Christina Stacey - RE: Mercy parking lot sign - Permit #2368

I am looking at the application for Mercy's new parking sign for the lot at the corner of State & Spring Streets. I had a couple quick questions that I hoped you could answer:

ALTA/ACSM Land Title Survey

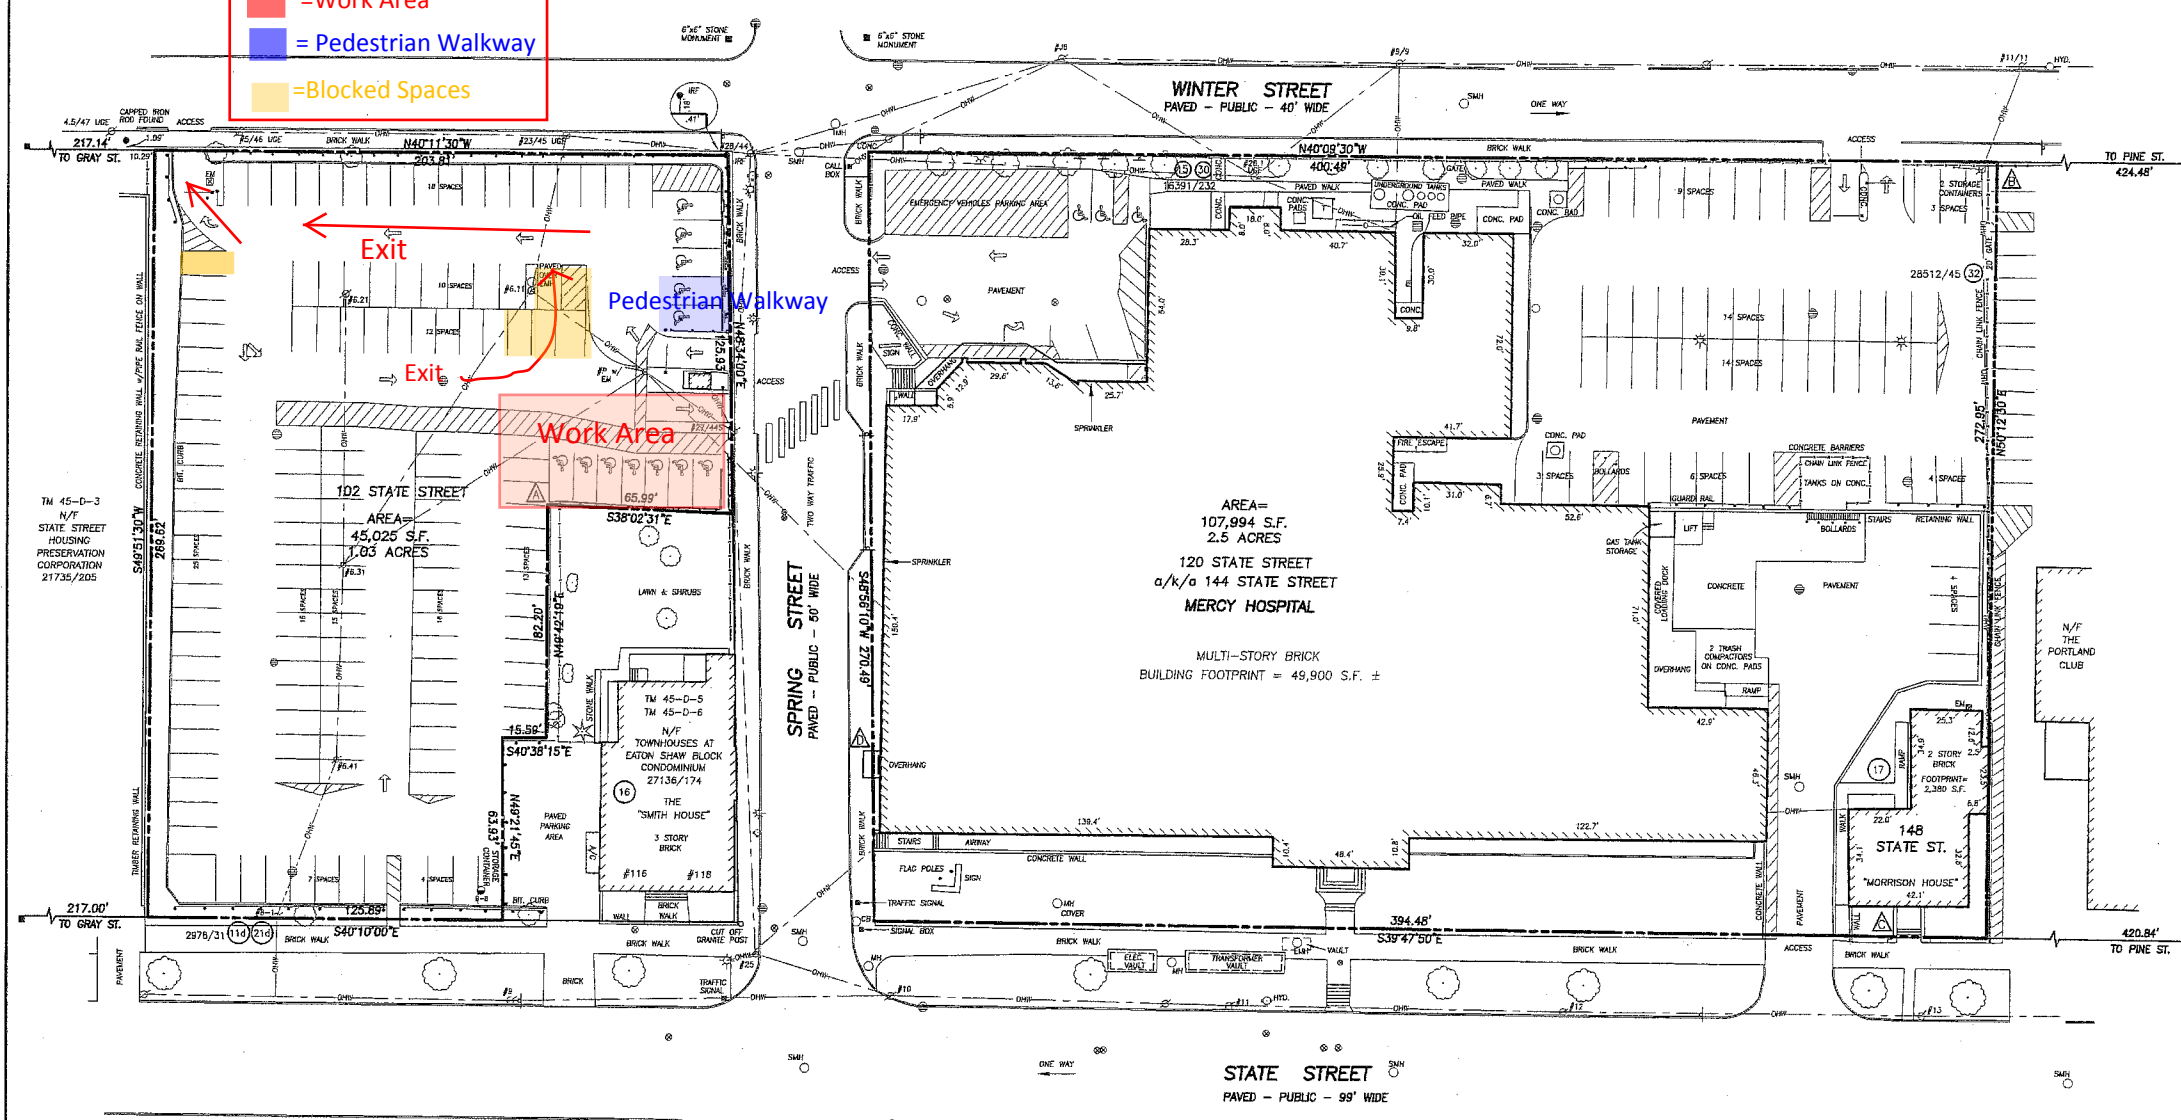
- 1) What is the approximate distance between the two back legs of the sign (i.e what is the spread at the back of the triangle)?
- 2) What will the setback be from the property line to the front leg of the sign? Based on the submitted survey plan, it looks to be somewhere between 4 and 5 feet. Please be aware that signs must be set back at least 5 feet from the property line.

The distance between the legs is 72"

The sign will be 5' 10" from the edge of the property line,
